## **Colorado Springs, CO**

### **Final Report - Corrections Required** **Application No. ZONE-25-0021**

**Document Filename : 25 0604 14-257080 VILLAGE C - MIXED USE M.pdf**

**LEGAL DESCRIPTION – ZONE MX-M**

EXHIBIT 'B'
 BANNING LEWIS RANCH
 ZONE MIXED USE
 MEDIUM SCALE (MX-M)
 JOB NO. 2570.80-14
 JUNE 4, 2025
 SHEET 2 OF 2

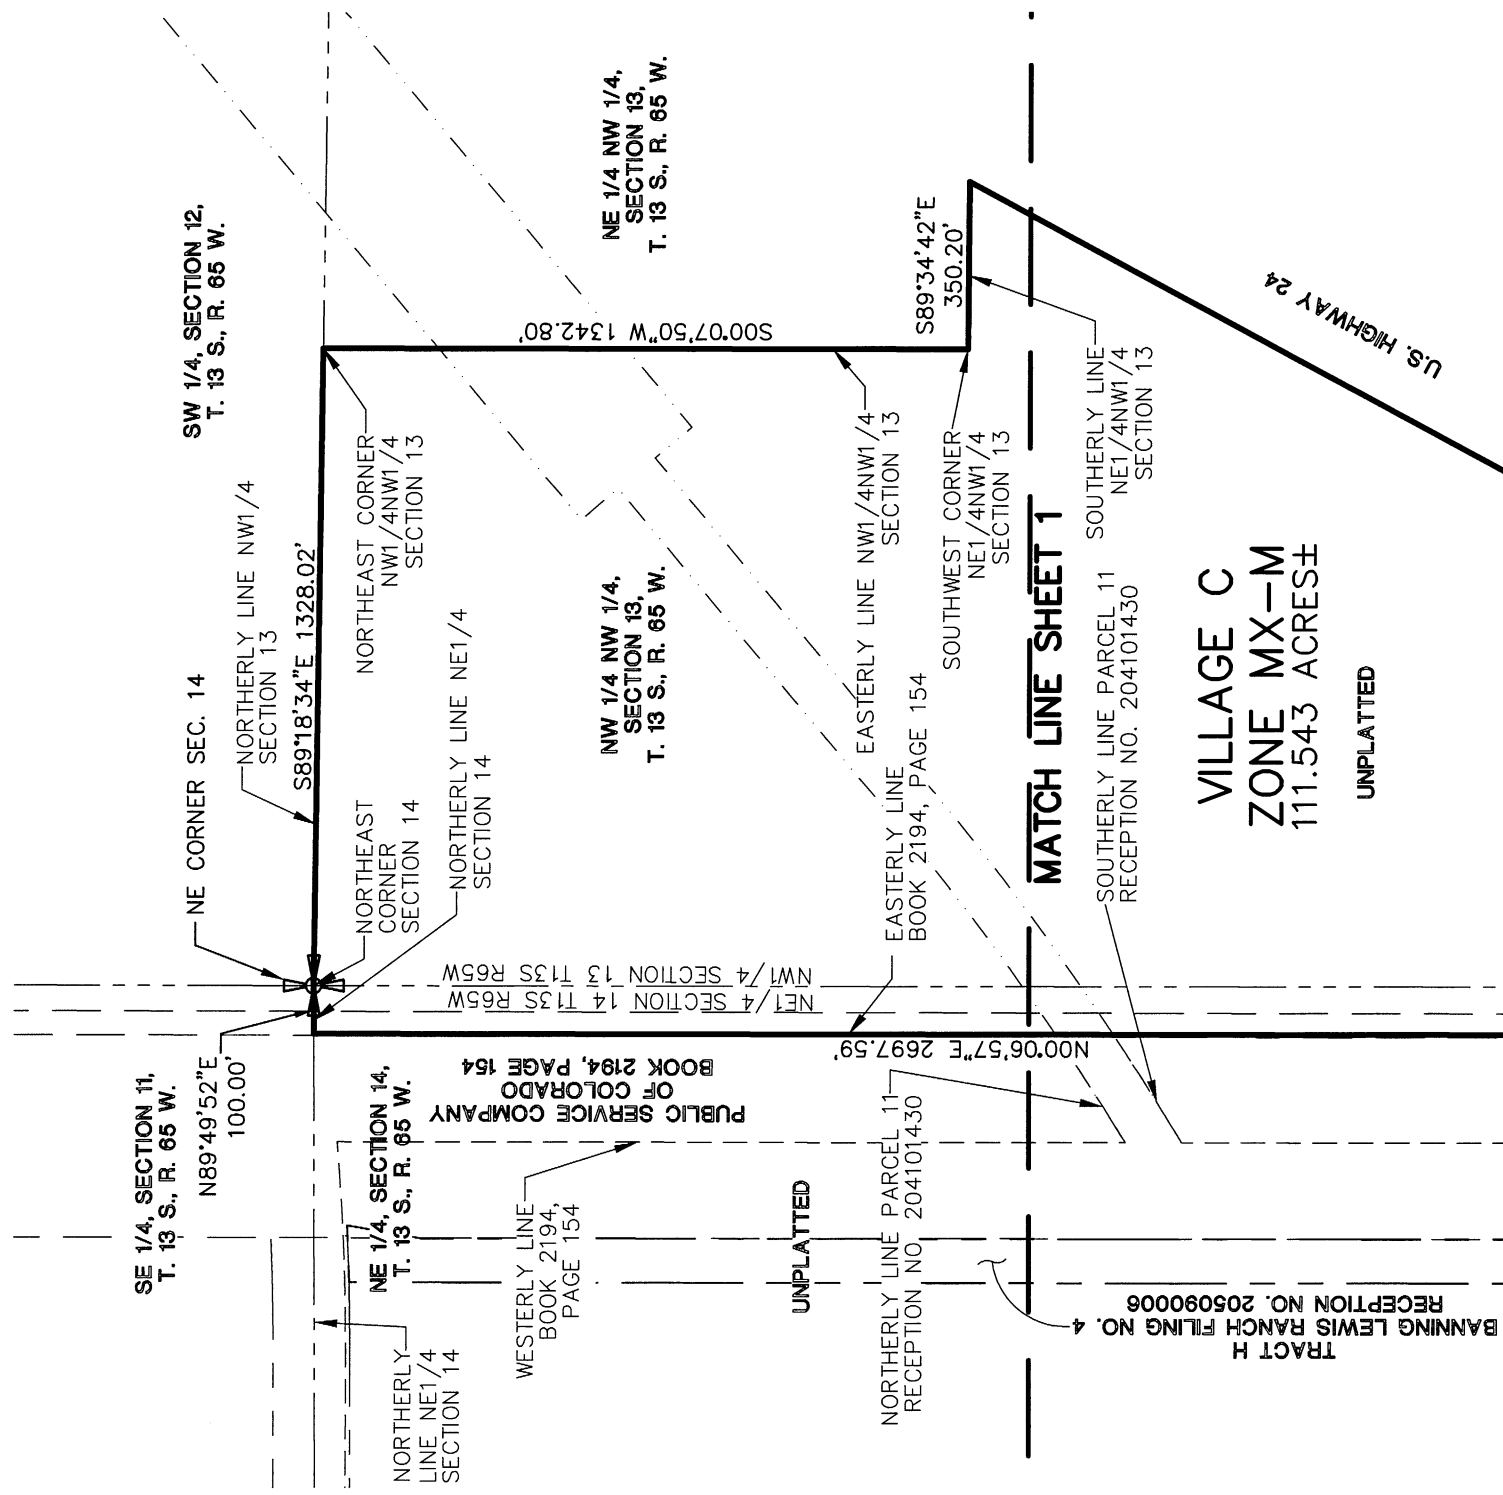
<b>Comment ID</b>	<b>Page Reference</b>	<b>Reviewer : Department</b>	<b>Review Comments</b>
3	1	Allison Stocker : Planning	The subject property is outside of the Streamside Overlay boundaries as defined by Section 7.2.603B. As such, the Streamside Overlay district does not need to be included in the zone change. No further comments
7	1	Cory Sharp : Planning	please add the City File No. ZONE-25-0021 in the lower right hand corner of all 4 pages
11	1	Cory Sharp : Planning	please remove the blank
8	2	Cory Sharp : Planning	2 of 4
9	3	Cory Sharp : Planning	3 of 4
18	3	Tamara Baxter : Planning	Please change to "MX-M / SS-O"
10	4	Cory Sharp : Planning	4 of 4
